**Our ref:** HA/2017/119575/01-L01  
**Your ref:** LU/94/17/OUT  
**Date:** 18 July 2017

**OUTLINE APPLICATION WITH ALL MATTERS RESERVED FOR RESIDENTIAL RE-DEVELOPMENT COMPRISING OF 10 NO. DWELLINGS & ASSOCIATED WORKS (RESUBMISSION FOLLOWING LU/327/16/OUT) WESTHOLME NURSERY TODDINGTON LANE, LITTLEHAMPTON, WEST SUSSEX, BN17 7PP.**

© This drawing is the copyright of Robert Clark Associates Limited It may not be copied or reproduced without their written authority	
Scale As shown	At original A2
Drawing Number 1696/D1.1	Revision A

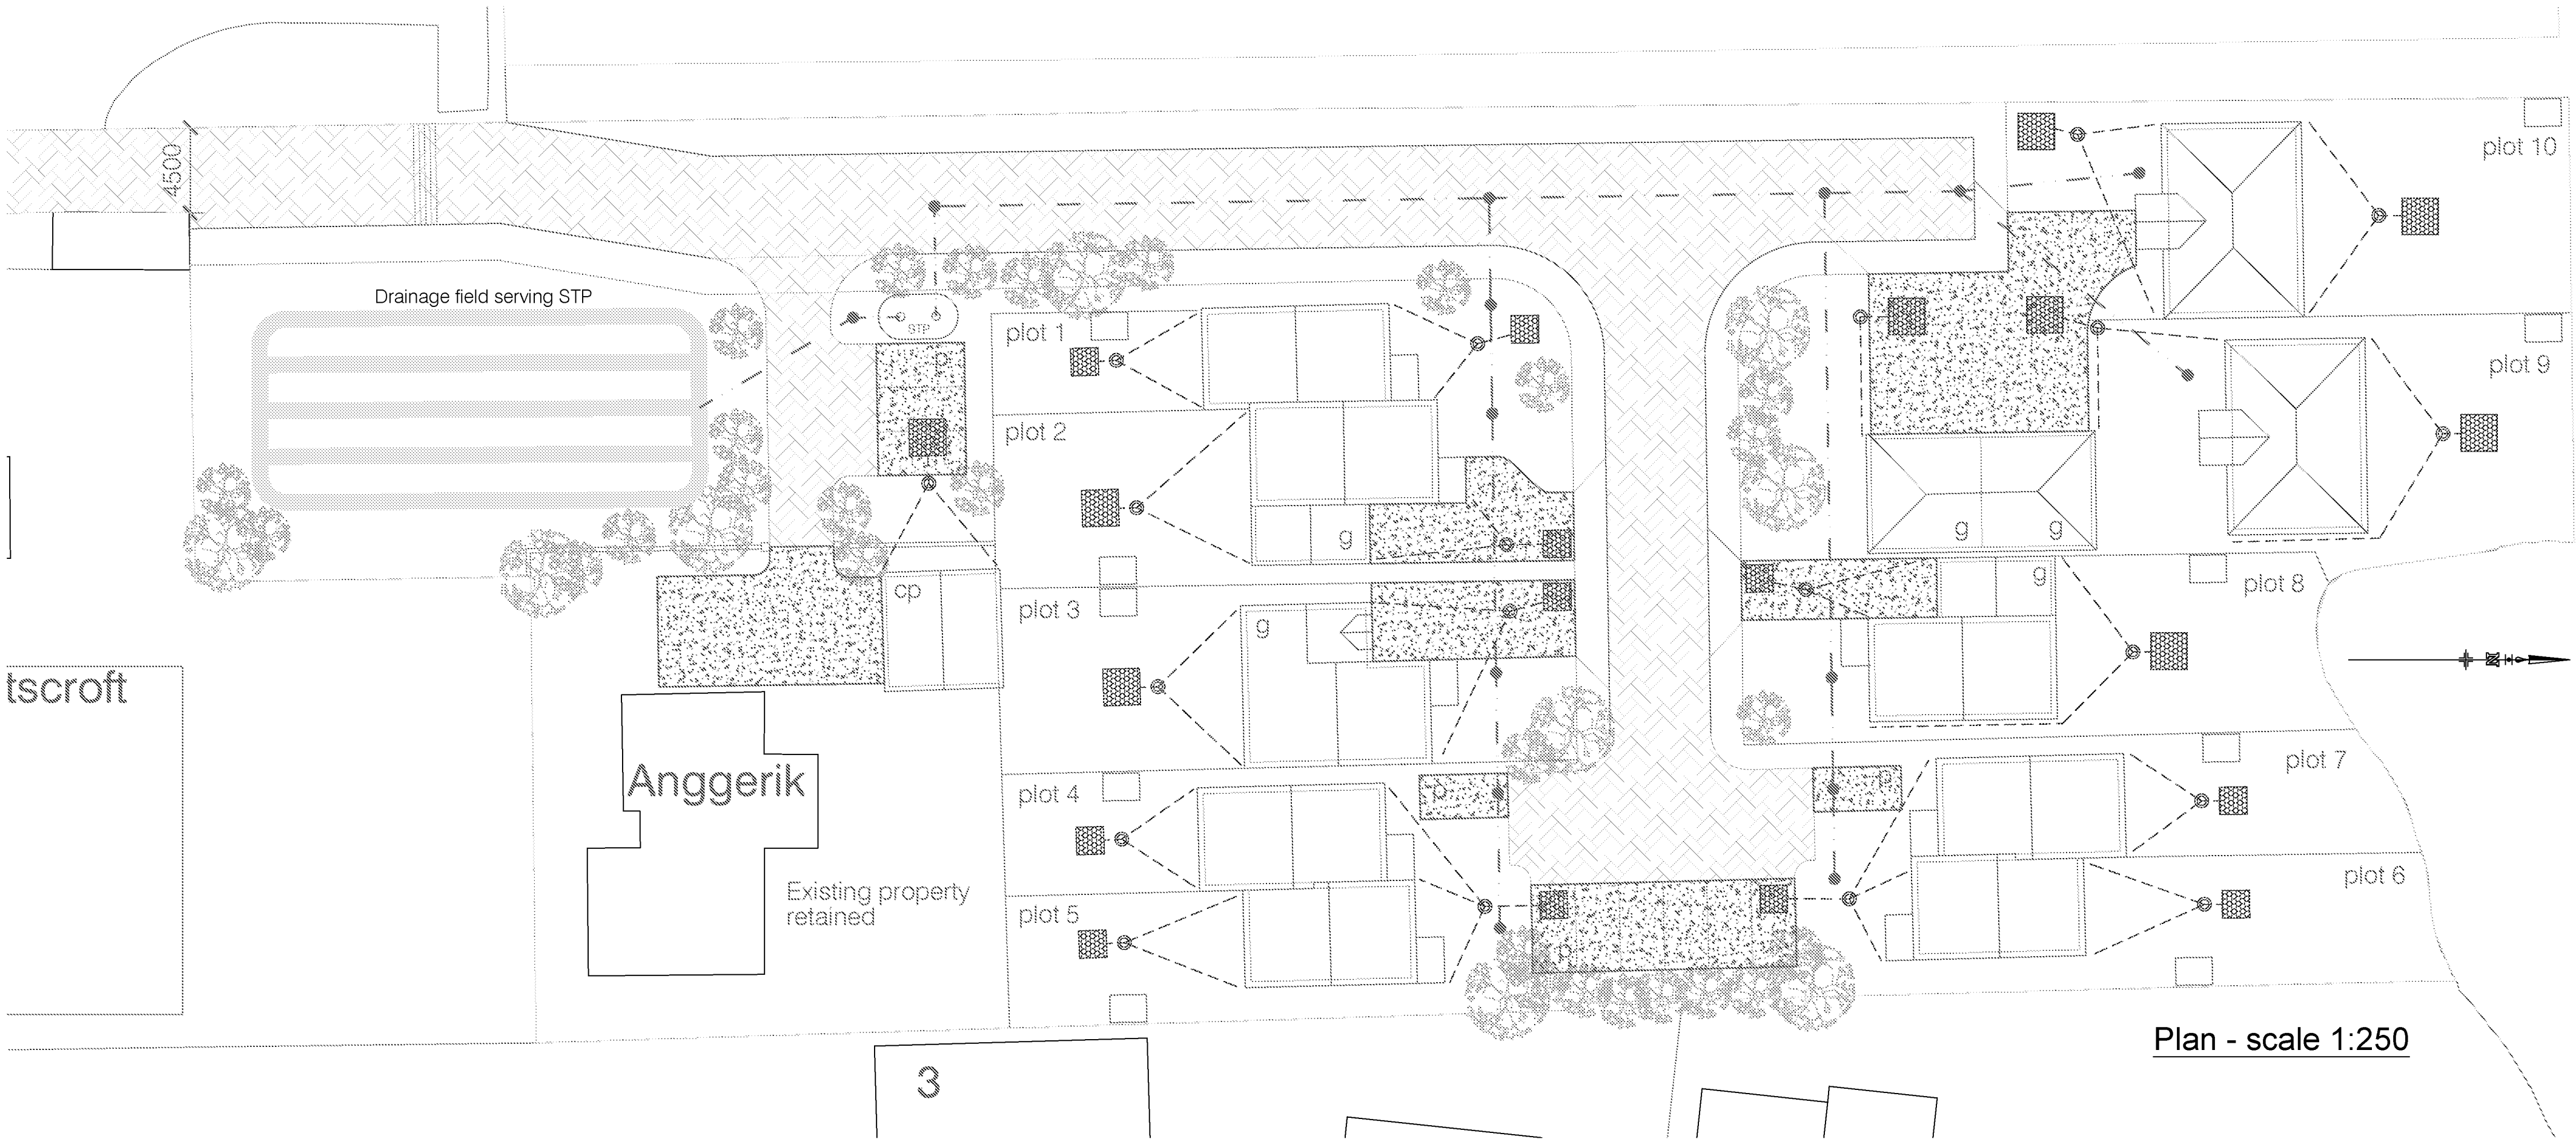
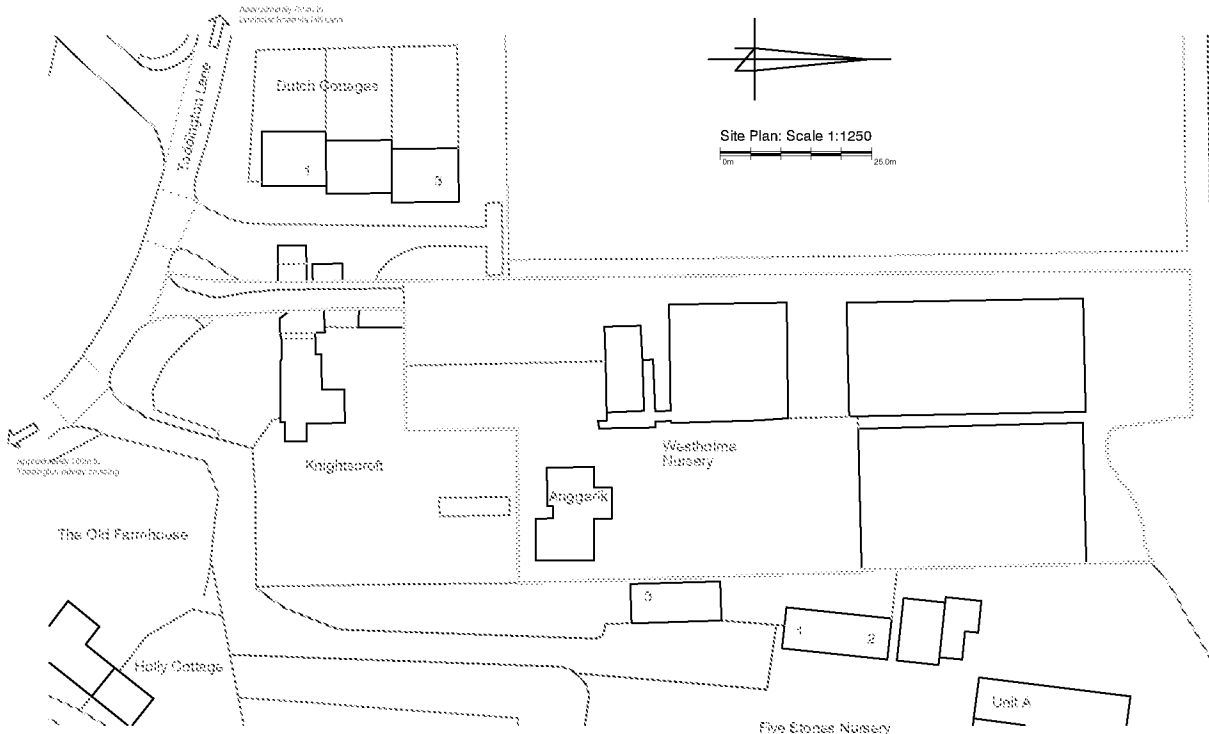
We note that this development proposes to dispose of foul drainage through an on-site package treatment plant. Considering the current location of the mains sewer network and the size of this development this approach may be appropriate, however, we are aware that the larger development at Toddington Nurseries is currently being built out in close proximity to this site. When occupied the development will provide a public mains sewer network nearer to this site which would make a connection here more appropriate.

We consider that through the reserved matters application further consideration should be given to the proposed method of foul drainage and where possible seek to connect to the public foul sewer.

The development hereby permitted shall not be commenced until such time as a scheme to dispose of foul drainage has been submitted to, and approved in writing by, the local planning authority. The scheme shall be implemented as approved.
